**ANNEX 3
COMPLIANCE OF ENVIRONMENTAL STATEMENT WITH EIA REGULATIONS**

03. EAST ELEVATION

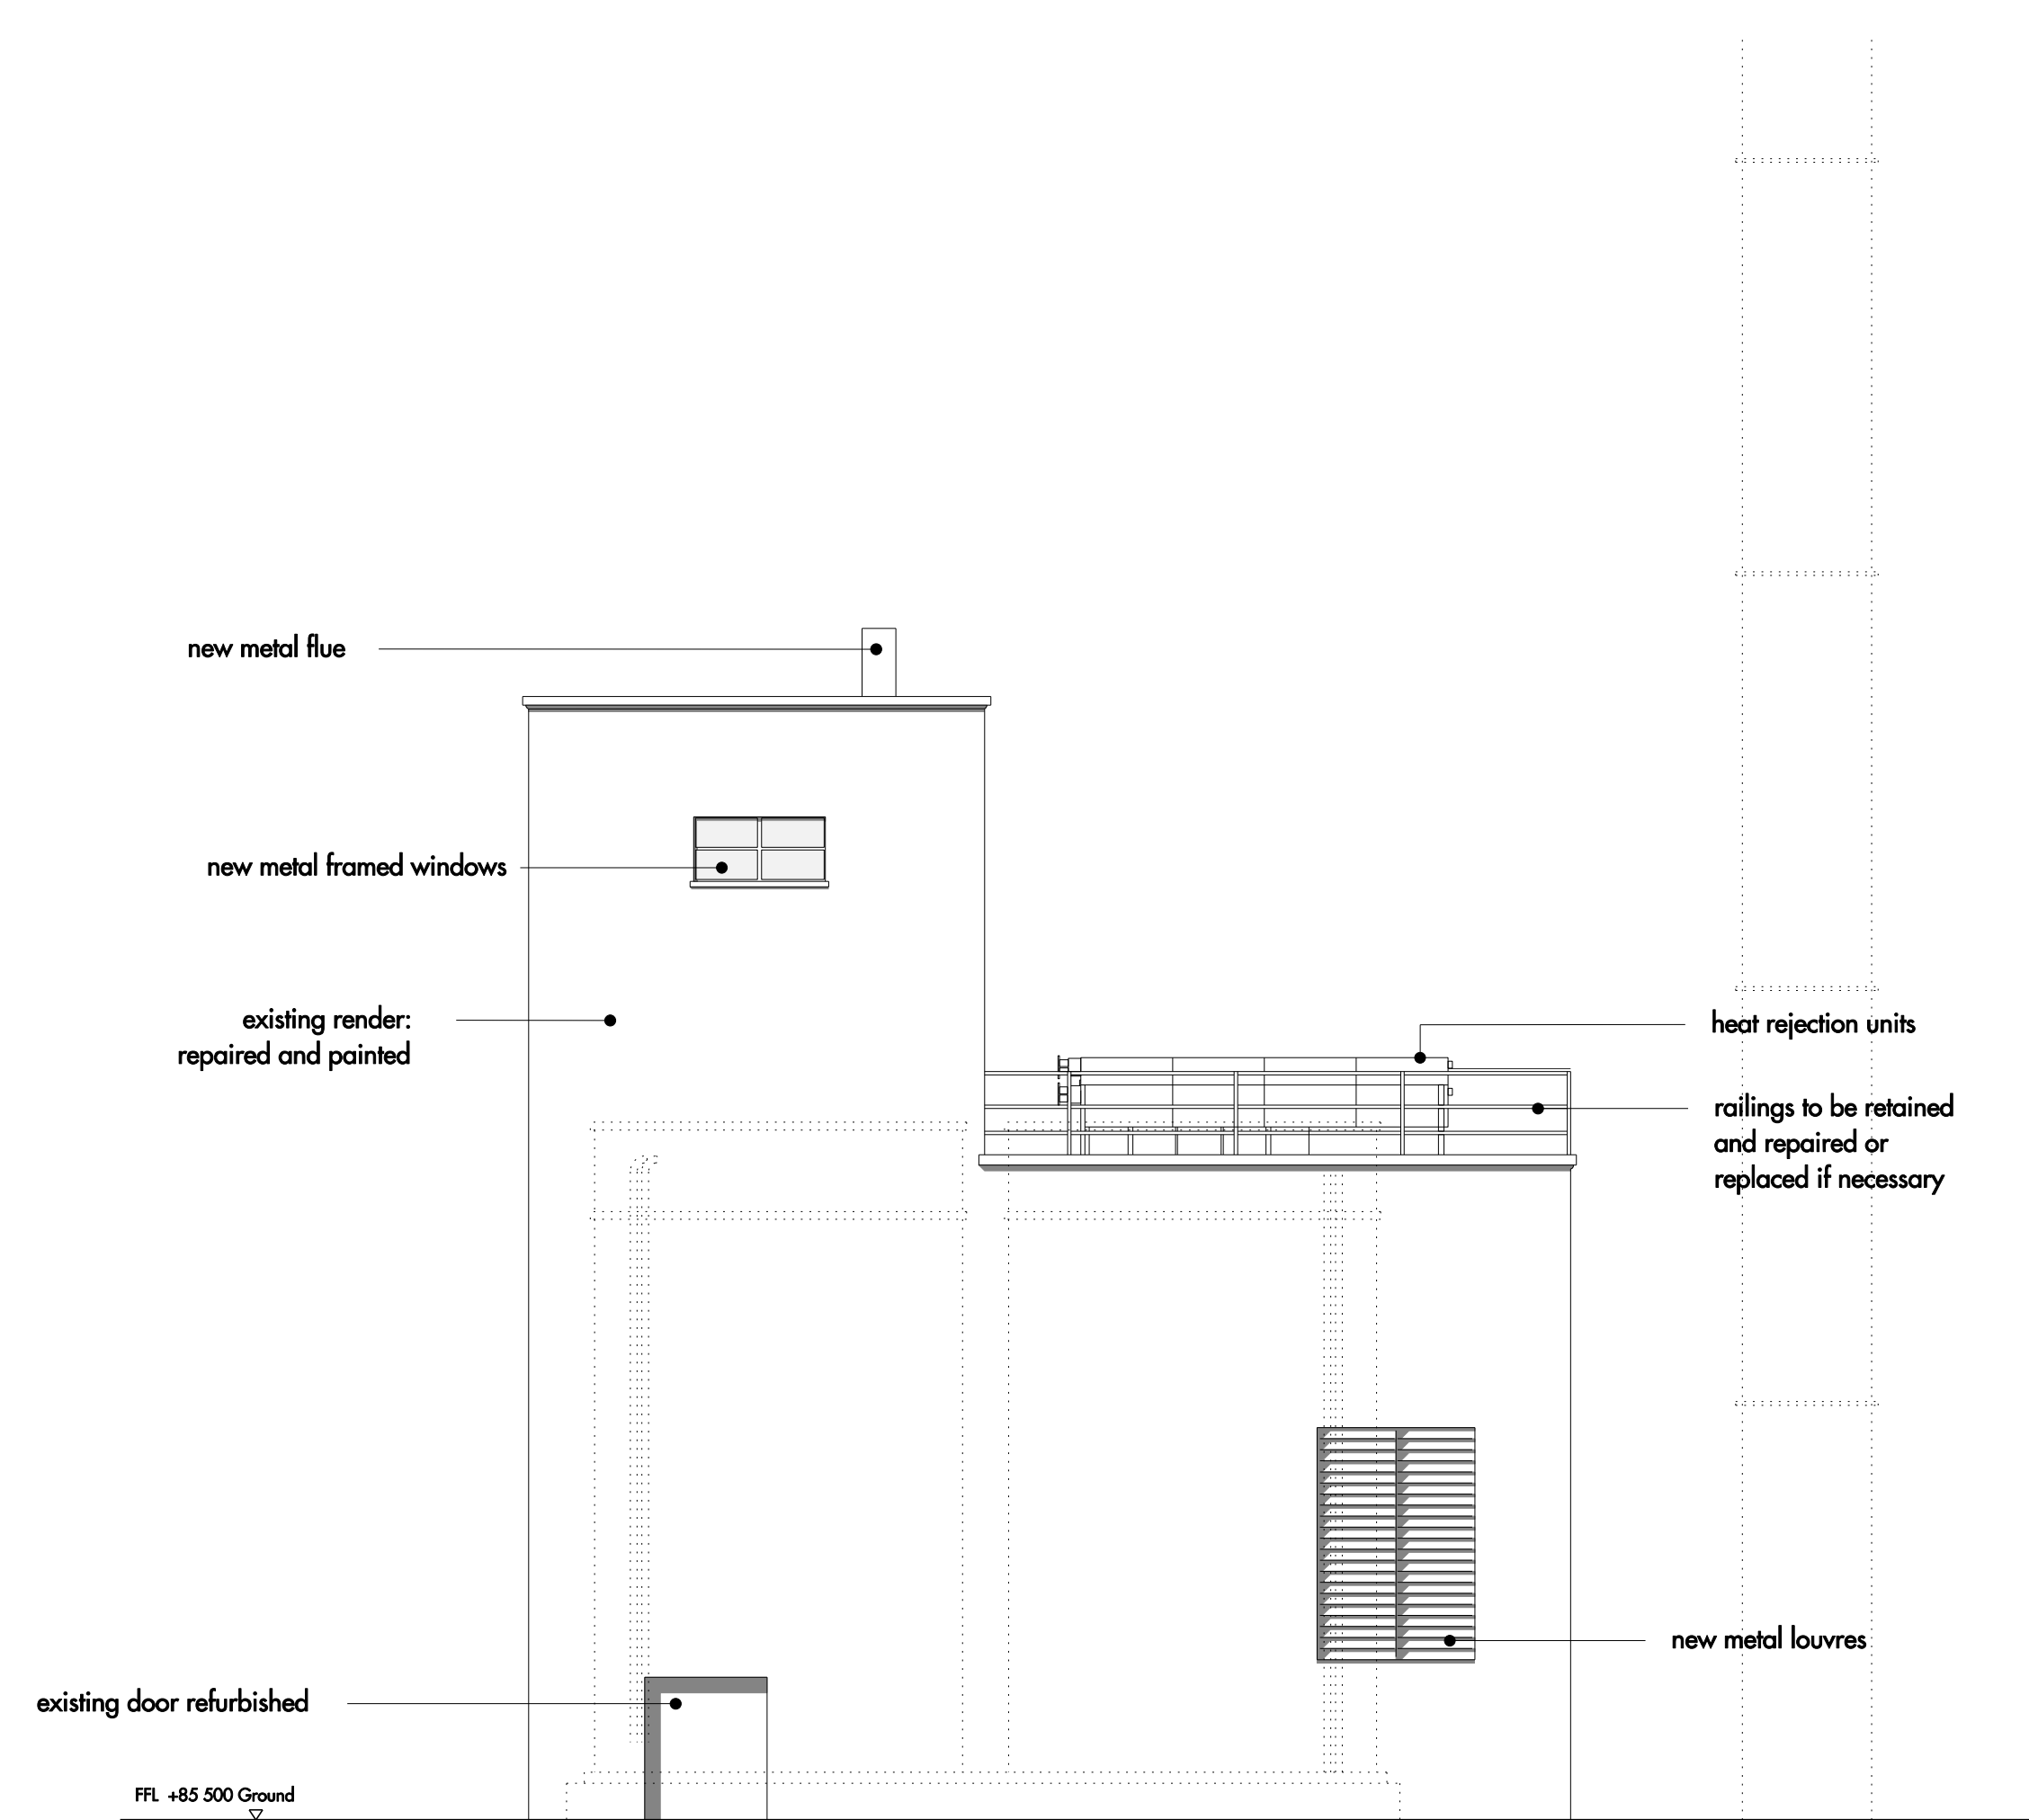
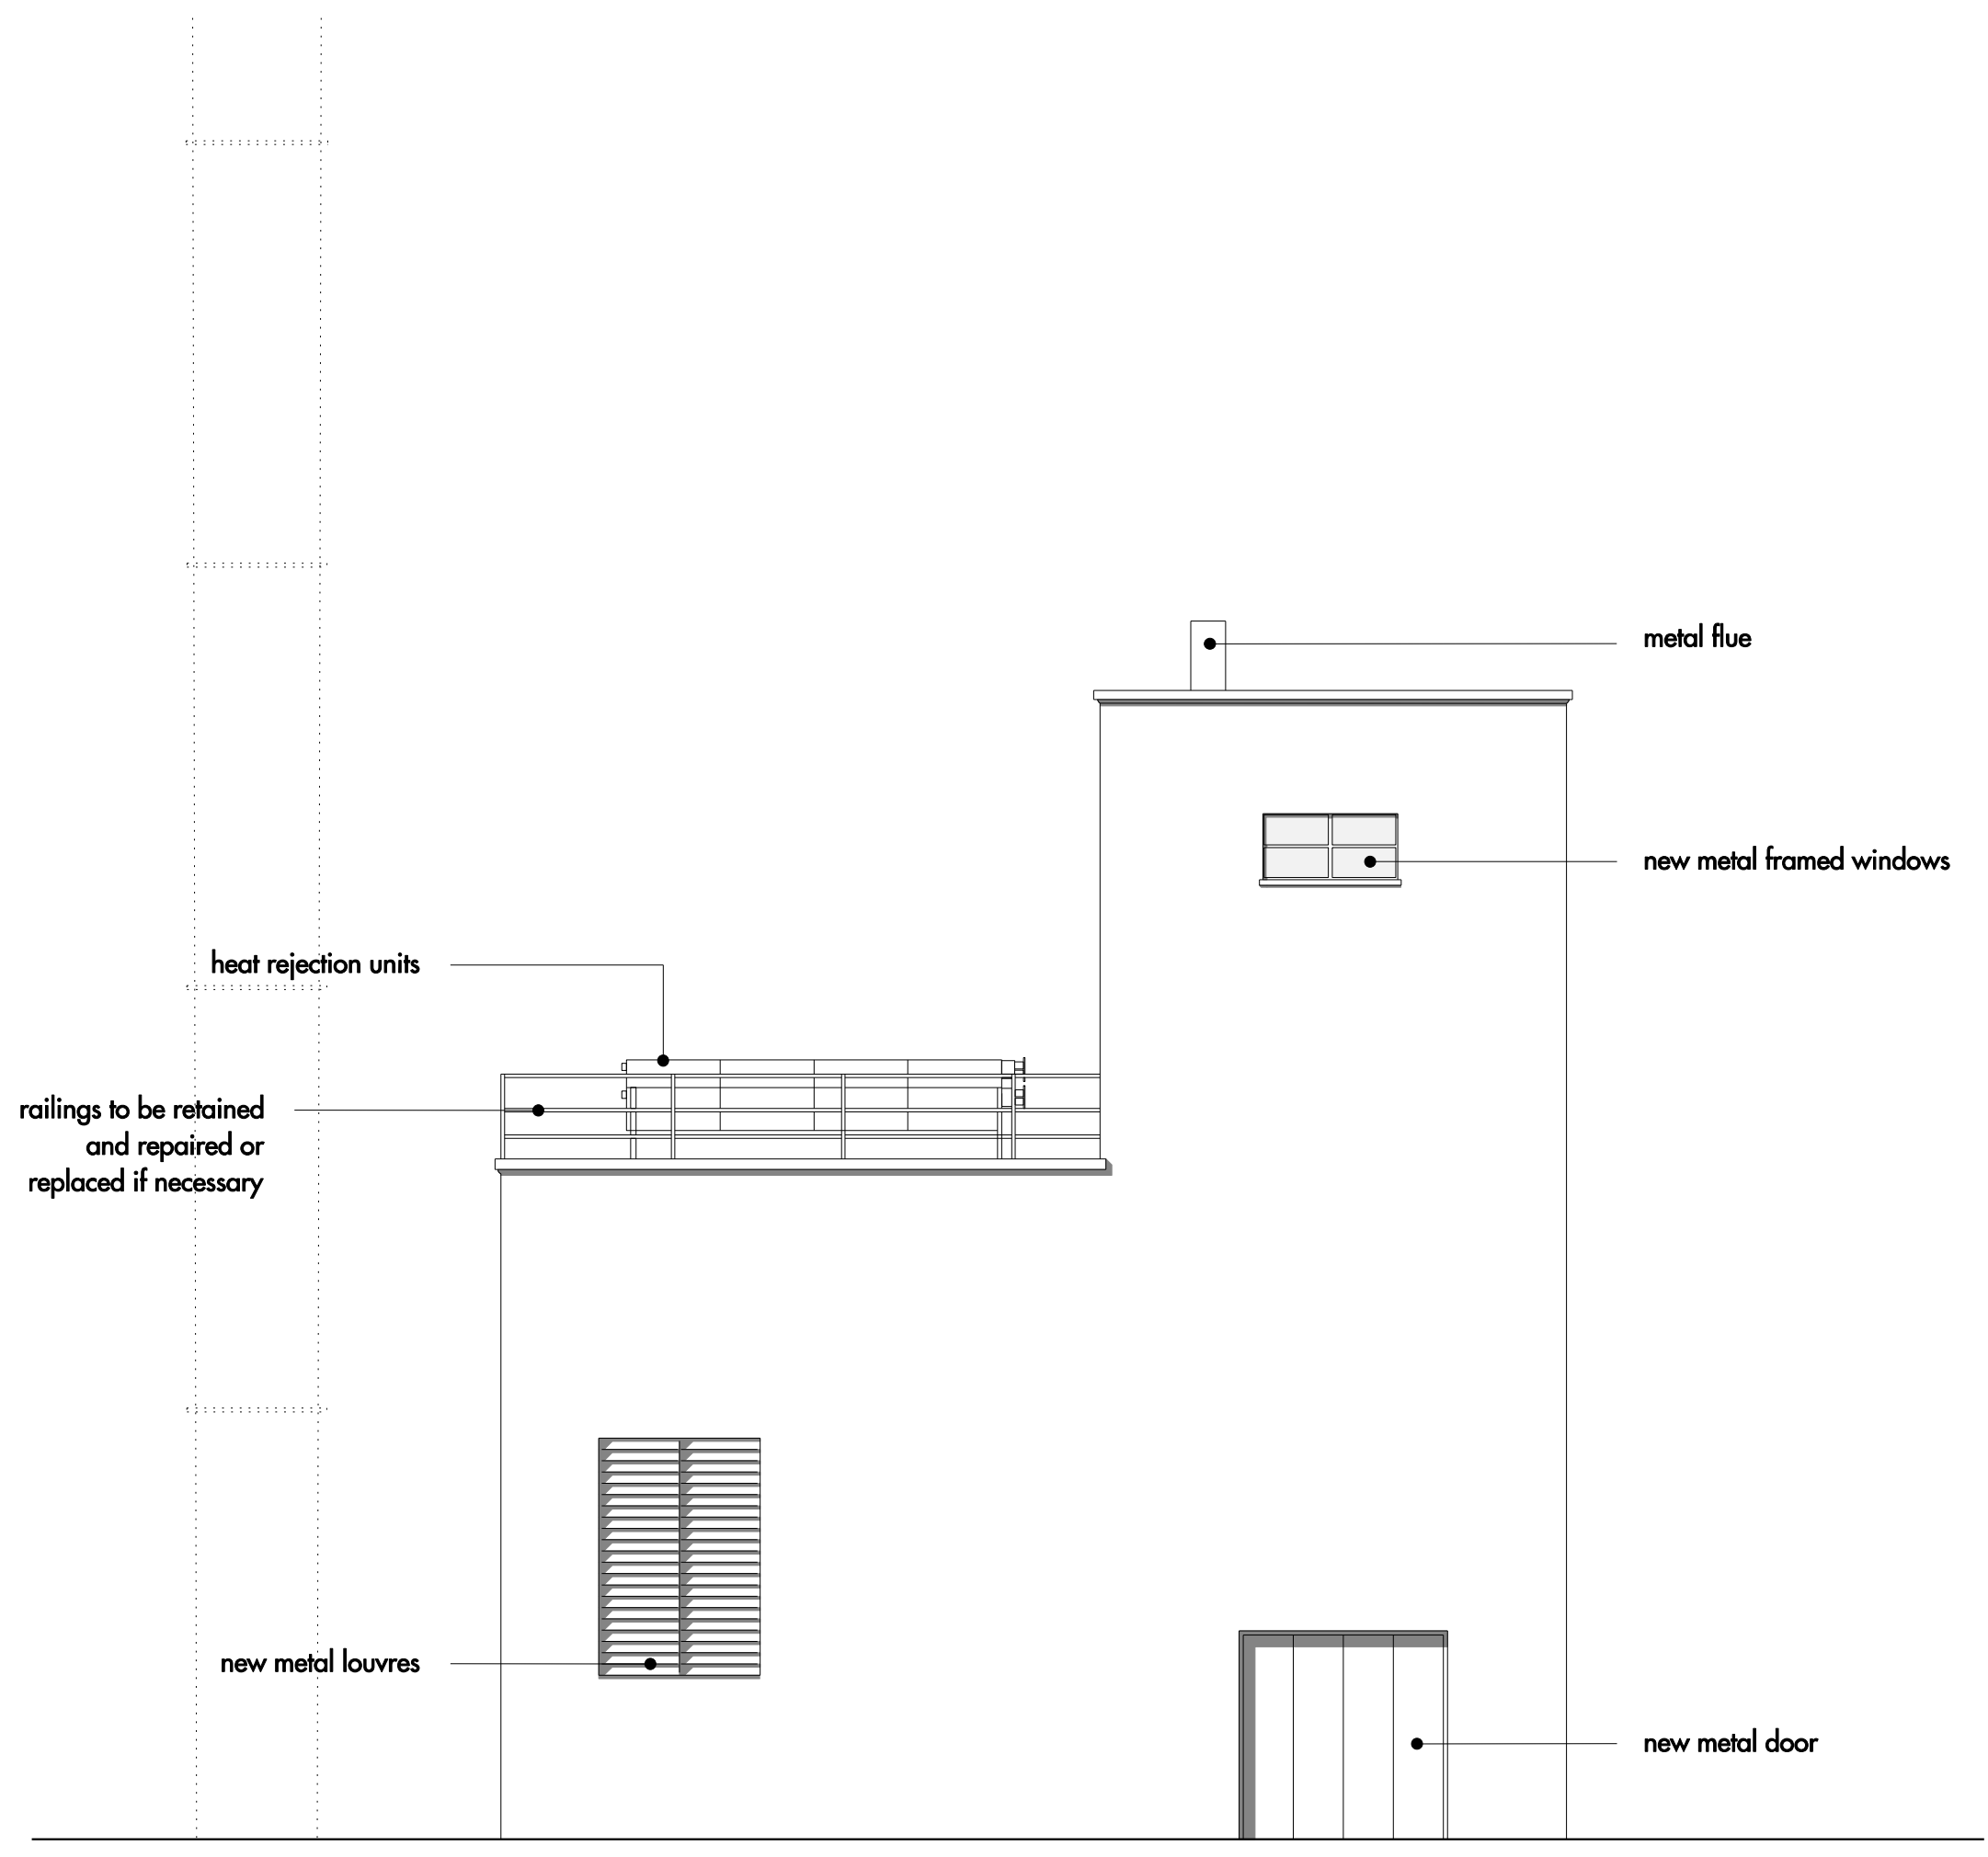
L,C,B,S Ref	ES Ref	Comments	Requirement under ES Regulations	Whether or not complies
		<p>Retained Tree 85 missing from proposals plans.</p> <p>Section 2.1.11 of Part B states that 3 CHP boilers + 3 gas boilers will be accommodated in the Energy Centre, but part C Volume 3 Appendix C seems less certain. Appendix C states that best practice will require individual flues for each of the three proposed CHP boilers, but there does not appear to be enough room for this (Appendix A). A planning condition requiring detailed proposals for flues to be submitted prior to commencement of construction would be appropriate.</p>		
<p>1.1.3 Indication of physical presence / appearance of the development</p>	<p>Section 2 of Part B of ES, and Section 2 of Volume 1 of Addendum. Plans and parameters plans in Part D of ES and Volume 3 of Addendum</p>	<p>Plans are generally clear and easy to reference. Plans and elevations provided for the detailed application area. Parameters plans provided for the outline application area.</p> <p>EIA Part D – Good level of information on general elevations & sections, with further information provided by detailed elevations More information provided by descriptions in Part B Section 2, with additional information in Vol 2 of the Addendum and by the photomontage views and descriptions (Section 5) in Part C Vol 3 Appendix B12 and in the Addendum to the Townscape and Visual Assessment</p>	<p>Not a requirement under the Regulations</p>	<p>B</p>
